RE: Project File Number, Brown and Jackson, SE-20-00003

Our written comments submitted are in regard to Washington State Environmental Policy Act (SEPA), Chapter 43.21C RCW, and Kittitas County Grading Permit public notice Brown and Jackson, SE-20-00003, dated, Monday, August 17, 2020. It is of our understanding that Kittitas County is acting as SEPA Lead Agency for the proposed project and proposed SEPA project actions and that Kittitas County is reviewing Brown and Jackson's June 11, 2020 Kittitas County, Department of Public Works, Grading Permit Application. However, based on review of the documents we understand we are commenting on the project as a whole, including, but not limited to, SEPA determination for Washington State Department of Ecology's General Permit for Biosolids Management.

**BROWN & JACKSON**  
 Land Application Site  
 Preliminary  
 Site Map  
 Kittitas County  
 Washington

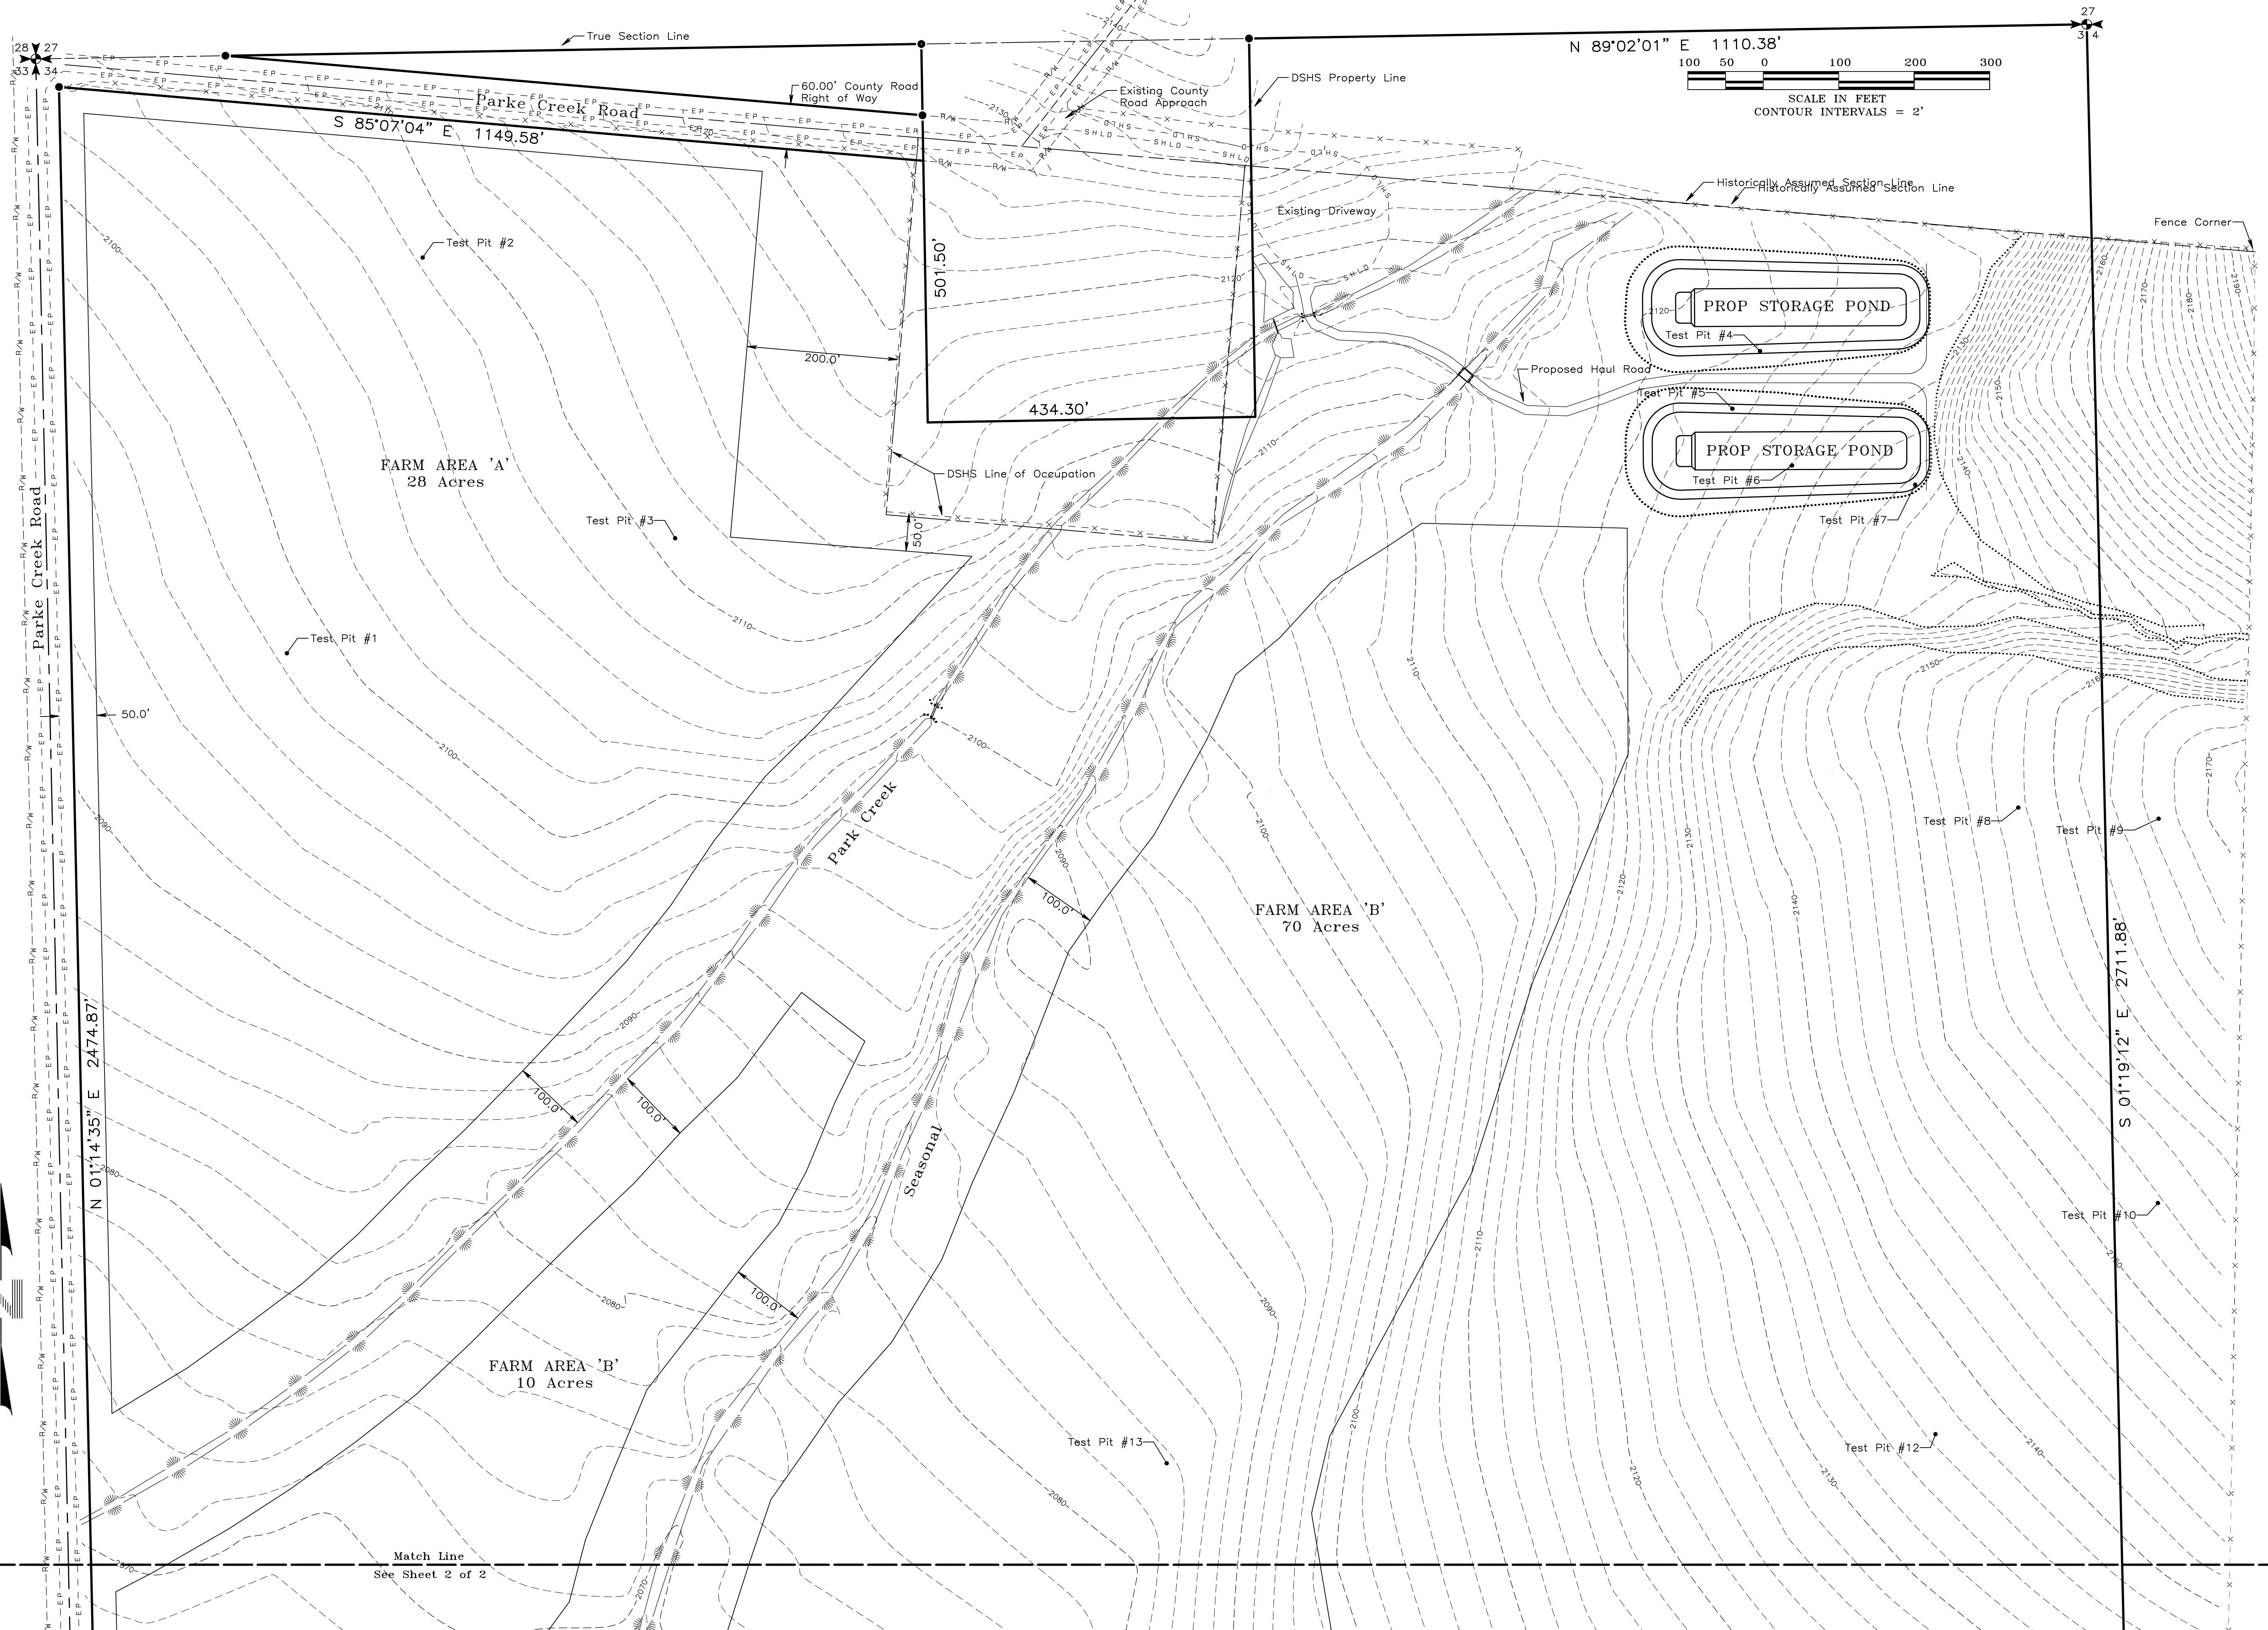
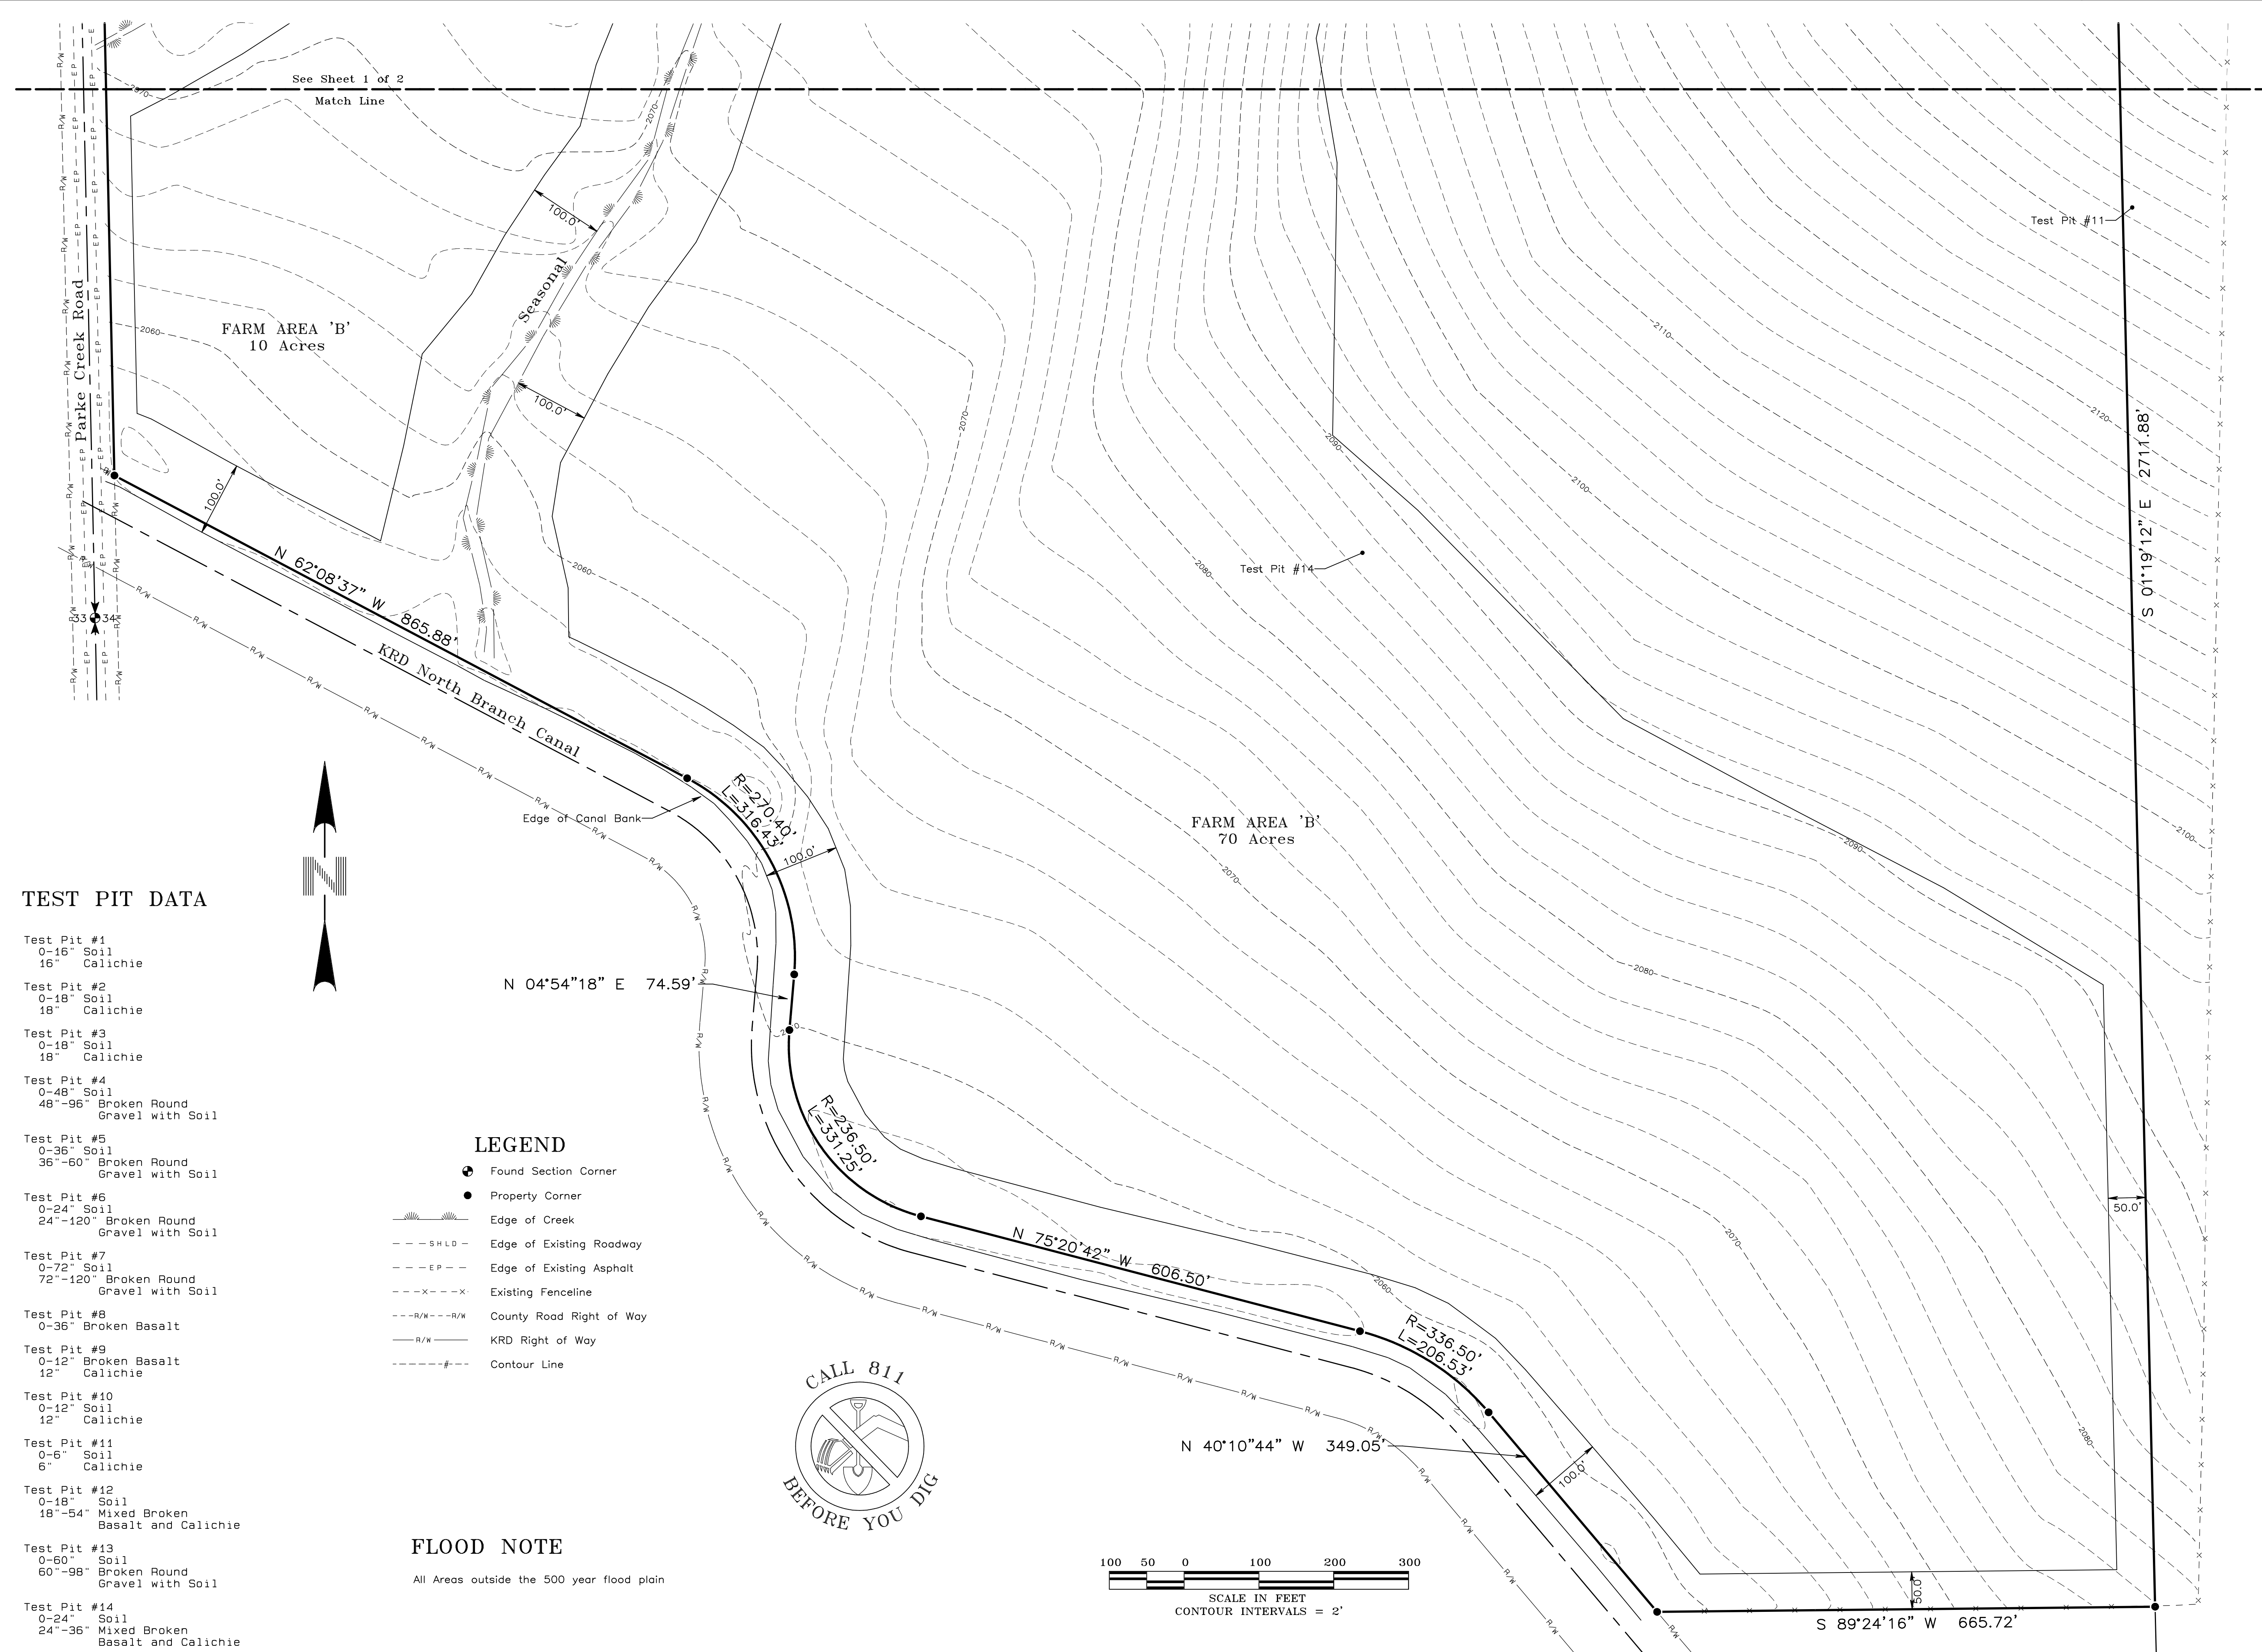
A.12.: Included Preliminary Site Plan does not appear to locate features, such as streams and irrigation ditches accurately. Included map in the July 30, 2020 Western Pacific Engineering and Survey document improperly characterizes Parke Creek's location with respect to the fields and proposed storage ponds. Parke Creek is the water body flowing from the north to south on the eastern-center portion of the site. The irrigation ditch, locally known as Parke Creek Ditch, flows from the east to the west across the site conveying irrigation and stock water to farms and ranches several miles downstream of the site. Please update maps and labeling.

A.1.: Parke Creek Ditch flows east to west diagonally across the project site. Parke Creek flows north to south across the project site. KRD North Branch Canal immediately abuts the project site to the south. 3 surface water bodies, total. Please update.
